**Consultation Response from KC,
Lead Local Flood Authority**

2023/91491 Prickleden Mills, Woodhead Road, Holmfirth, HD9 2JU

Erection of 61 age-restricted apartments with ancillary accommodation including separate residents lounge and manager facilities and associated external works, including the erection of access bridge and riverside walk featuring two pedestrian bridges (within a Conservation Area)

Date Responded: 20th December 2023

Figure 5.4 Location of Undercroft Car Park

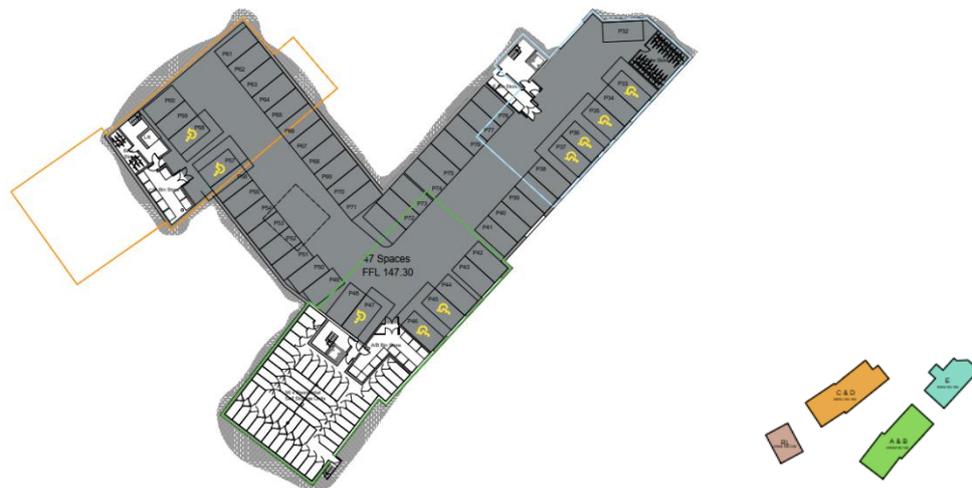
- **The undercroft comments stand.** To be clarified in the revised FRA.
- Surface water drainage strategy. What is the minimum orifice size acceptable to the Council. **75mm** We have amended the orifice size of the outfall to be a minimum of 75mm per outfall and calculated to associated discharge rate (see attached). This gives a total discharge rate for the site of 7.5 l/s (note we will update storage volumes etc on the drawings once the discharge rates are finalised).
